From: Anita Gardner
Sent: 23 January 2012 09:49
To: Planning.Responses
Subject: FW: Herne Farm House
Attachments: 2 Park Drive(rev 4)-01 EXISTING & PROPOSED A1.pdf; 2 Park Drive(rev 4)-02 ELEVATIONS PROPOSED A2.pdf

Herne Farm House

Issue	Details	By	Date
SCALE			AS SHOWN ON A2
DATE			11/11/11
DRAWING NUMBER			FILE NO/11041/02

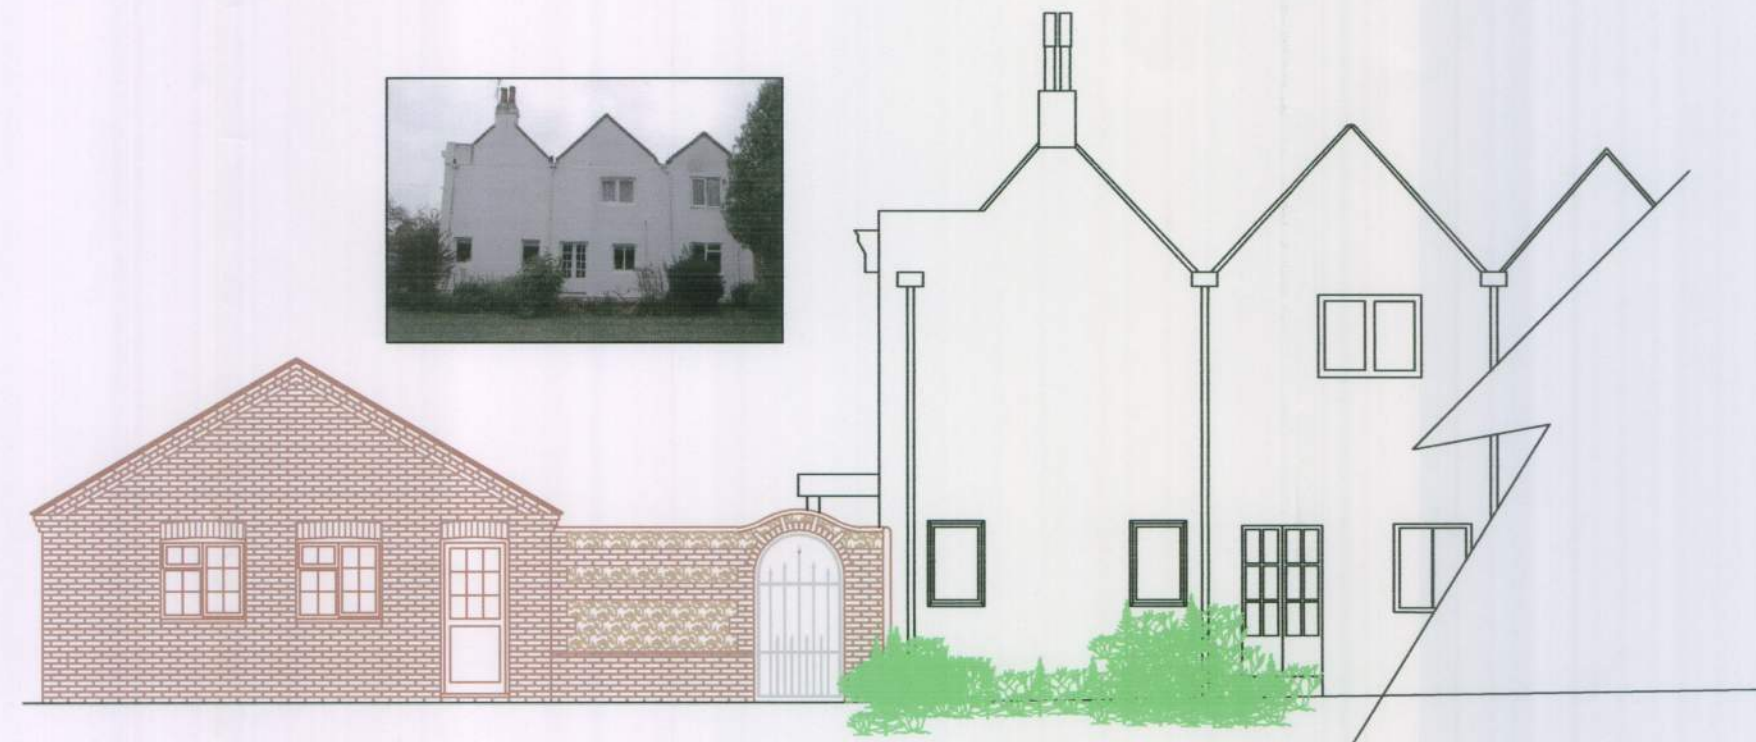
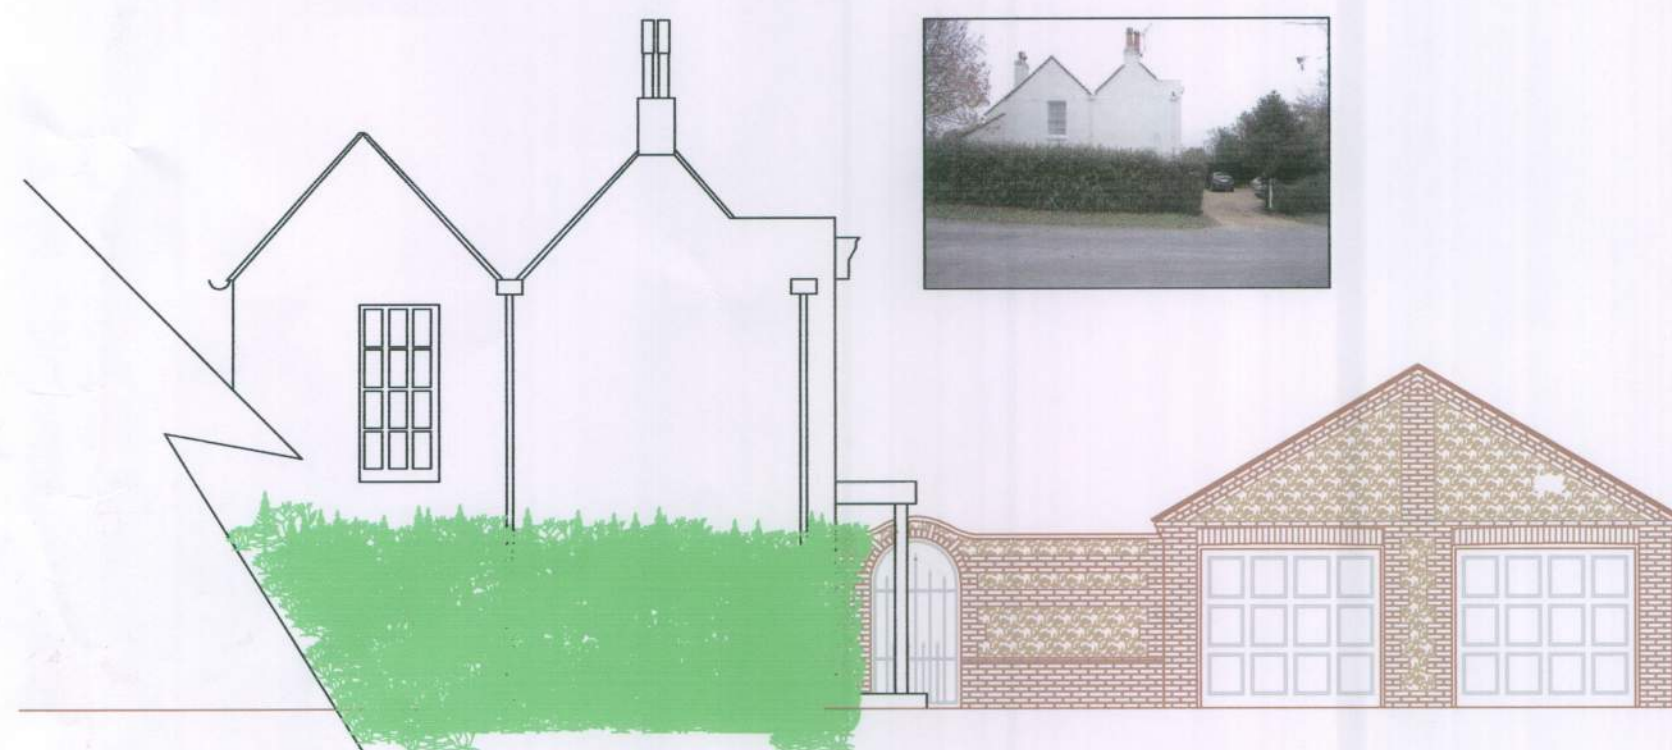
1 Revise the west side elevation to Drwg 11041/02 by replacing the flint in the two triangles above the garage doors with brickwork.

2 Redraw the revised Drwg 11041/02 to show the roof reorientated by 90 degrees ie so that the ridge runs N-S rather than the current proposal of E-W.

If it is possible easily and without too much effort and cost could you also change the brickwork pattern into Flemish bond on both the above revisions.

SCALE AS SHOWN ON A2
DATE 11/11/11
DRAWING NUMBER 11041/02/REV.A

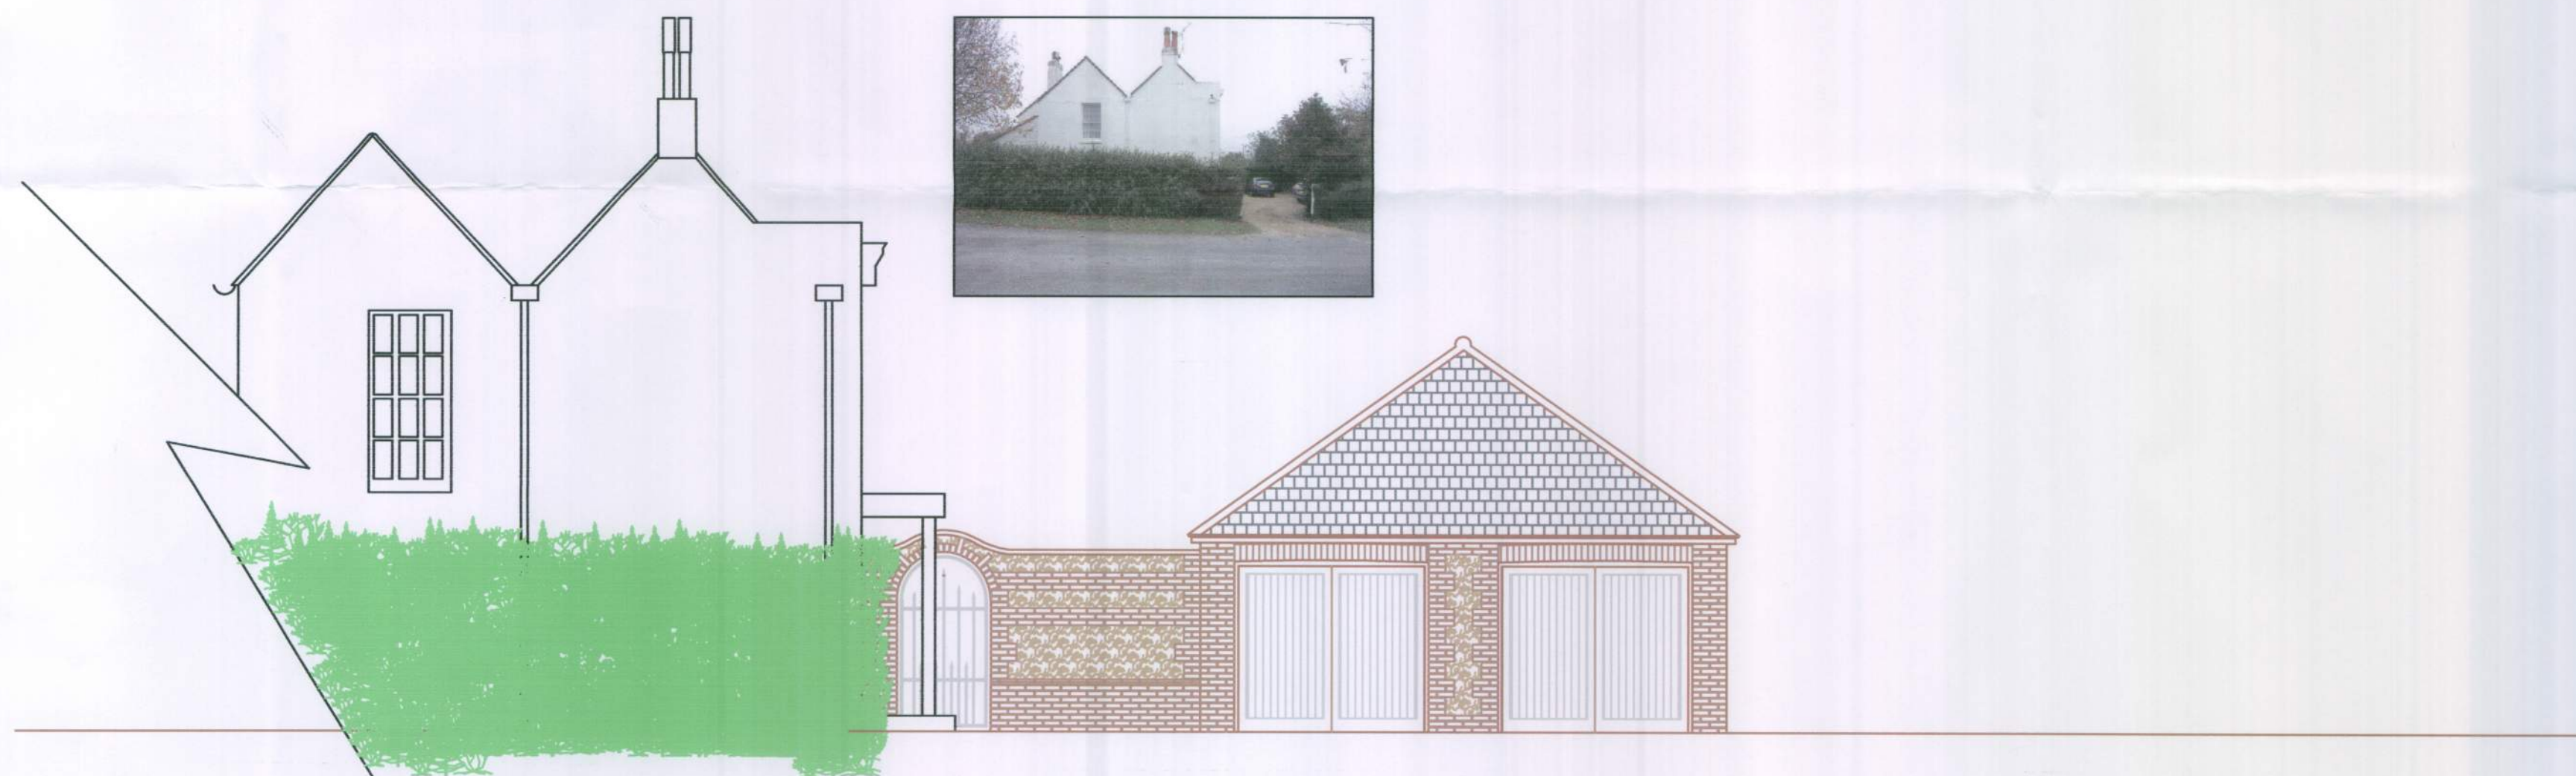
Attached to this email I am forwarding as promised copies of the two drawings illustrating the revised proposals for the garage. These latest proposals accommodate the amendments suggested by Ian Wightman and I hope therefore that they will be acceptable to you. Please note that although the drawings do not show it the brickwork will be in Flemish Bond pattern at Ian's request for consistency with the style commonly adopted on Georgian houses.
